CITY OF ALBUQUERQUE

RE: Pulte @ Mirehaven Phase 1 (File: H09D017B)
Grading and Drainage Plan, Engineer's Stamp Date 3-12-2014
Certification dated: 7-7-15 for ROFG

PULTE @ MIREHAVEN PHASE 1
GRADING PLAN

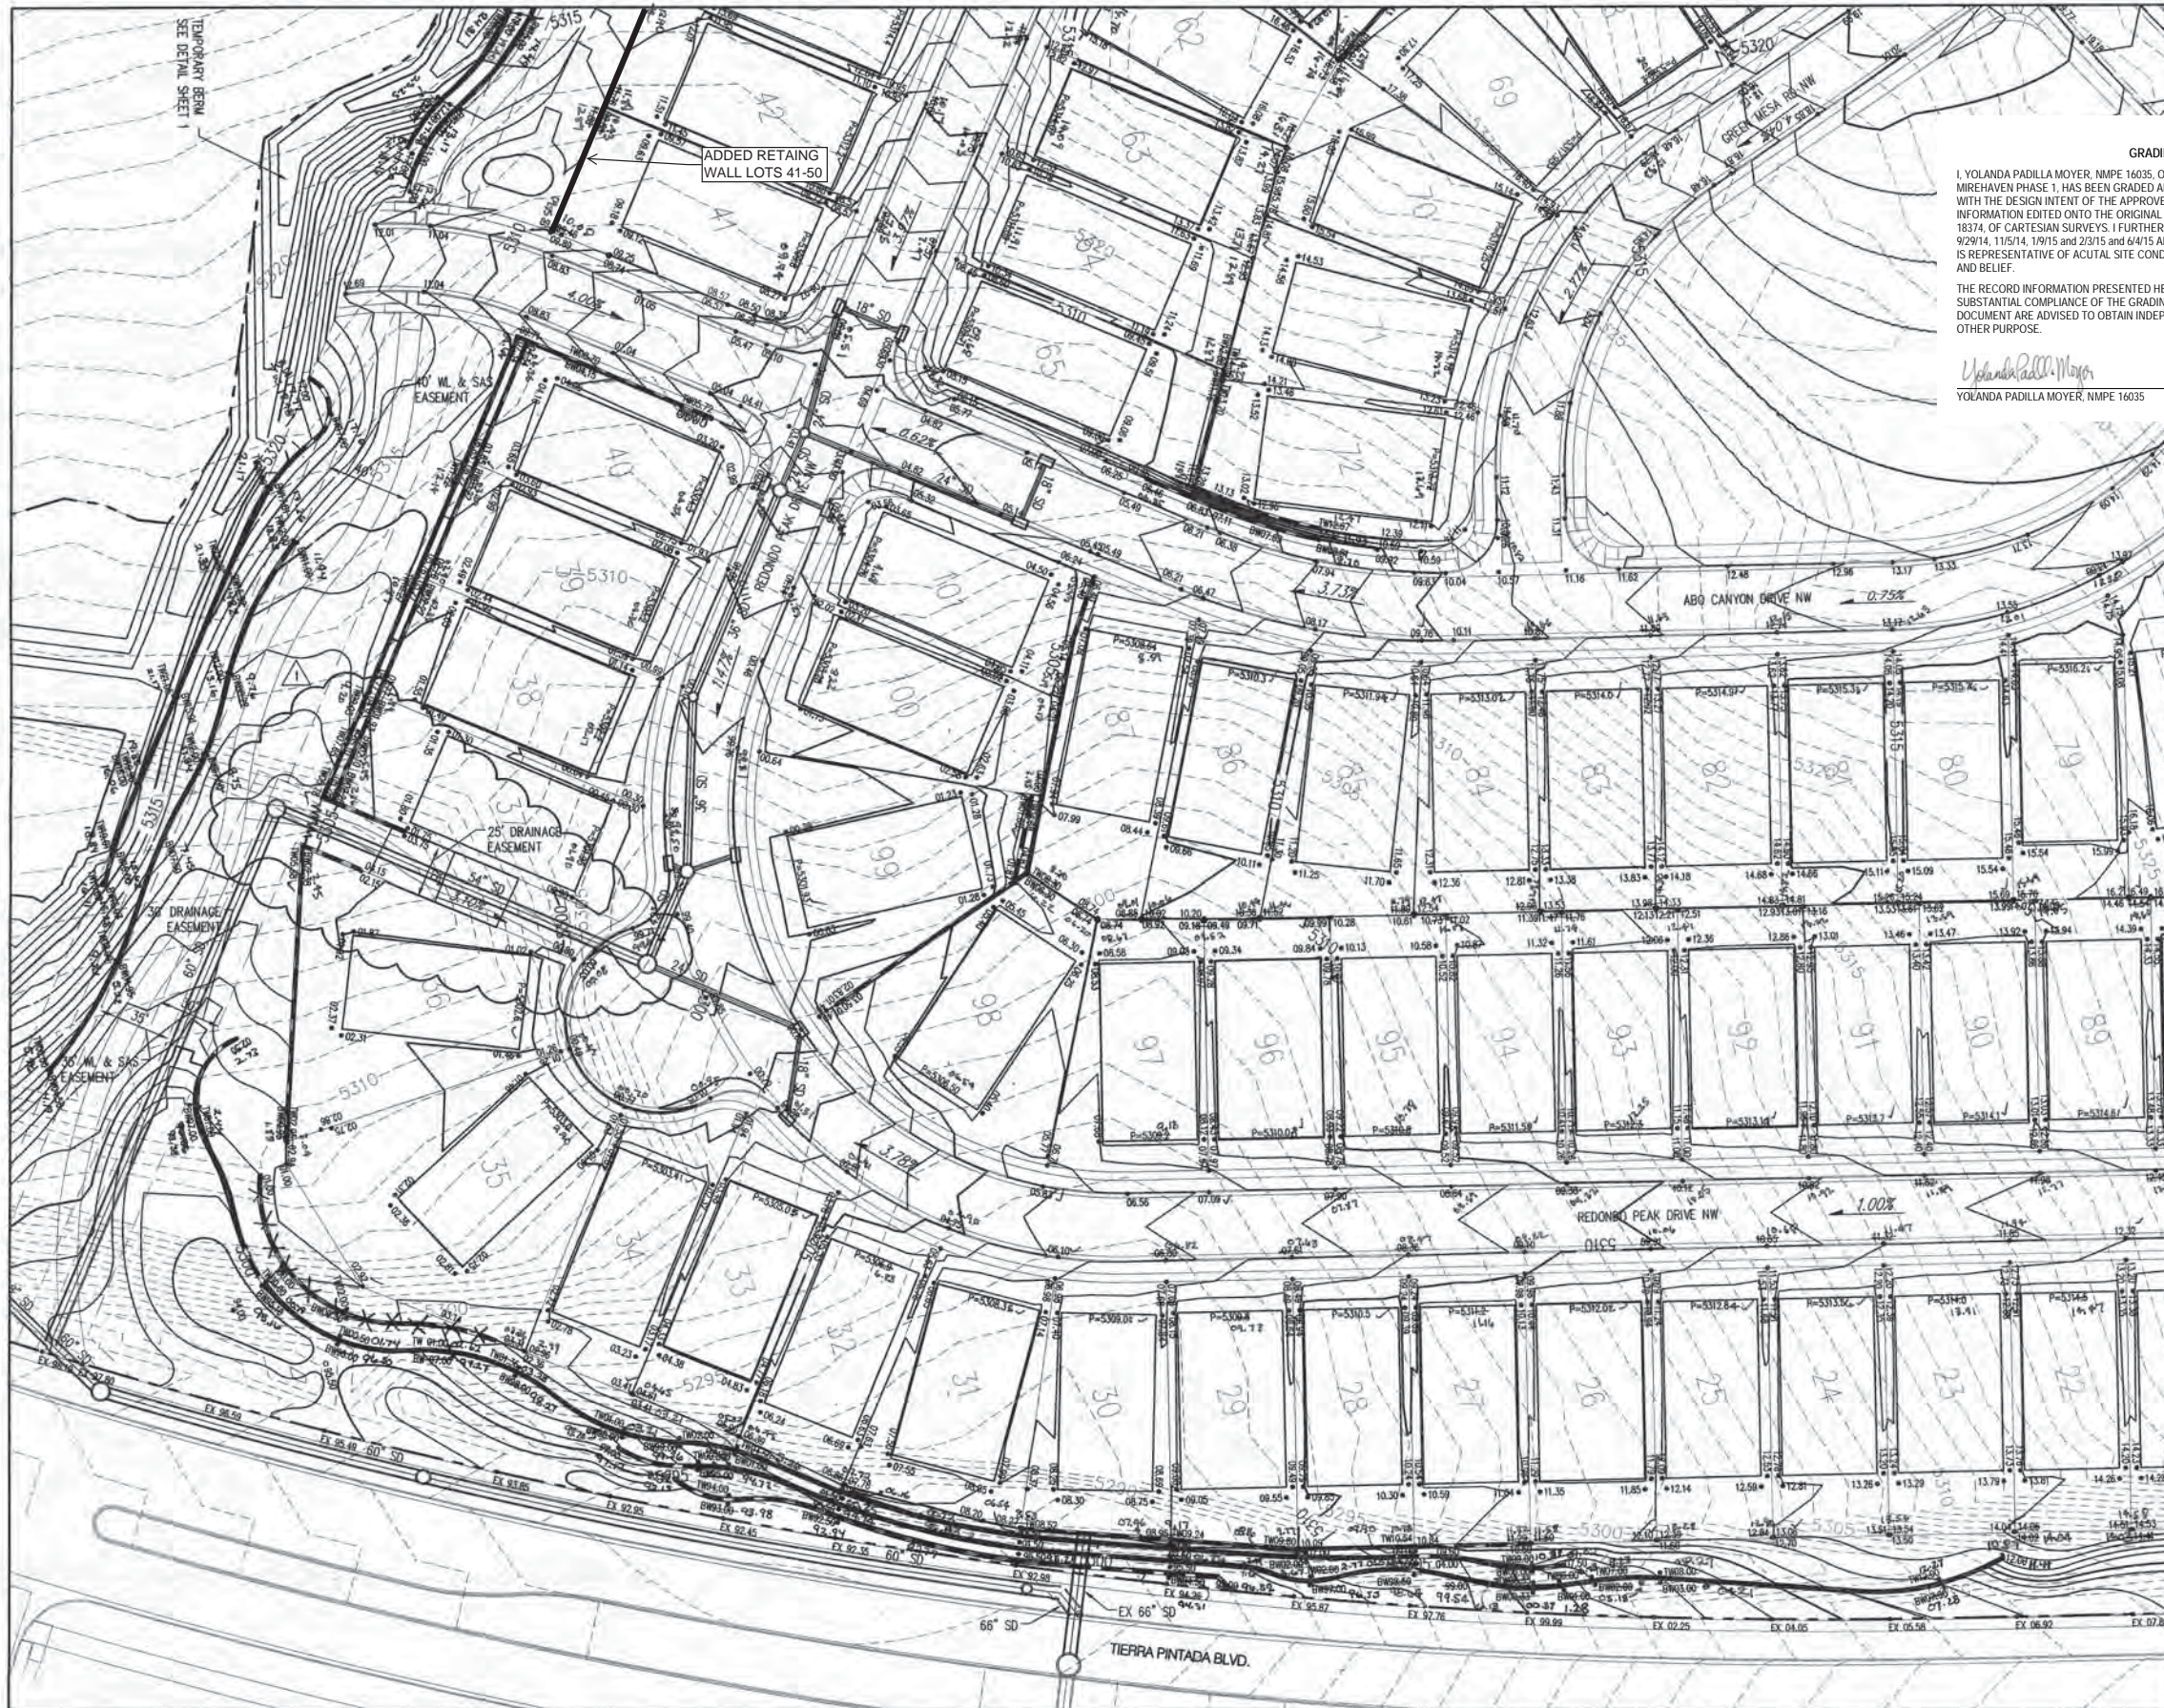
- The Temporary Pond south of the subdivision will need to be restored to the grades shown on the Grading Plan. At present, there is sediment that is above the invert elevation of the storm drain. (see attached photo)
